Subject: FW: 5557 L.P BR/252/21/PL & BR/253/21/PL - 67 to 71 Upper Bognor Rd - UPDATE ON RECOMMENDATION - EOT BATS

7 Parking

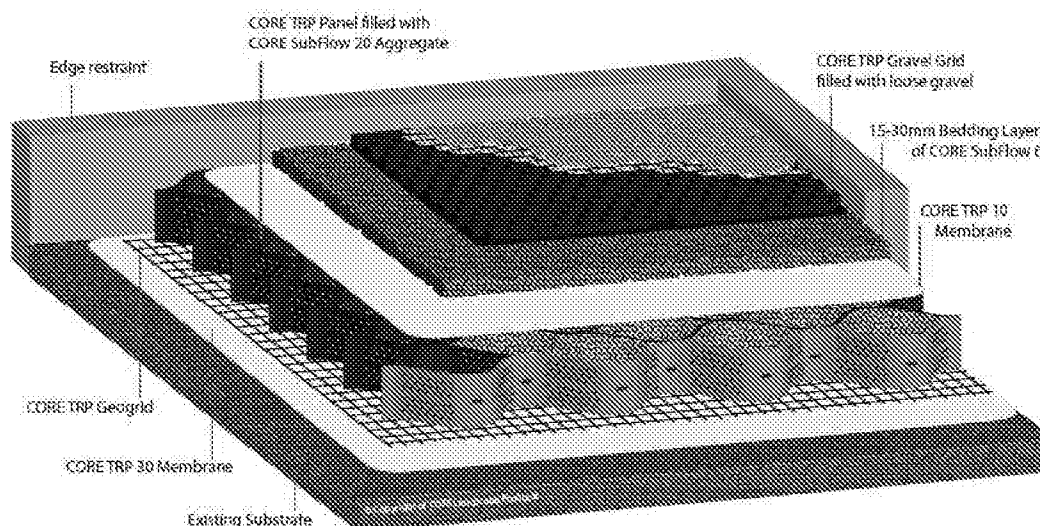
As per our previous response, we have no concerns over the details provided and displacement if any, from parking spaces being restrictive (estimated to be in the range of 1 – 3) would be considered an amenity issue. To be considered by yourselves.

The applicant has also stated that a refuse vehicle can reverse into the site for bin collection. This is not an acceptable practice and a turn on site should be provided if refuse access is proposed. However, they do also state that bin collection roadside has been proposed and accepted previously. The LPA may wish to determine these details now or at the discharge of conditions stage with the following condition.

With regard to the WSSC highways comments, we do not understand the comments re accessing the parking spaces. There is at least the standard 6.1m behind all the parking bays and the low wall to Charlotte House stops 3.5m short of the end of the parking bays so providing adequate room for cars to enter and exit.

In the planning officer's report to the 2019 application it was noted that 'a refuse vehicle would be unable to enter and exit the site in a forward gear. The LHA has indicated that road side collection is suitable along Upper Bognor Road.' We have indicated on the site plan how it would be possible for a refuse truck to reverse into the site to facilitate bin collection.

*No part of the development shall be first occupied until the vehicle turning space has been demonstrated within the site in accordance with plans and details **to be** submitted to and approved by the Local Planning Authority. This space shall always thereafter be kept for their designated use.*

I think any minimal parking displacement is likely acceptable, and we could condition the turning.
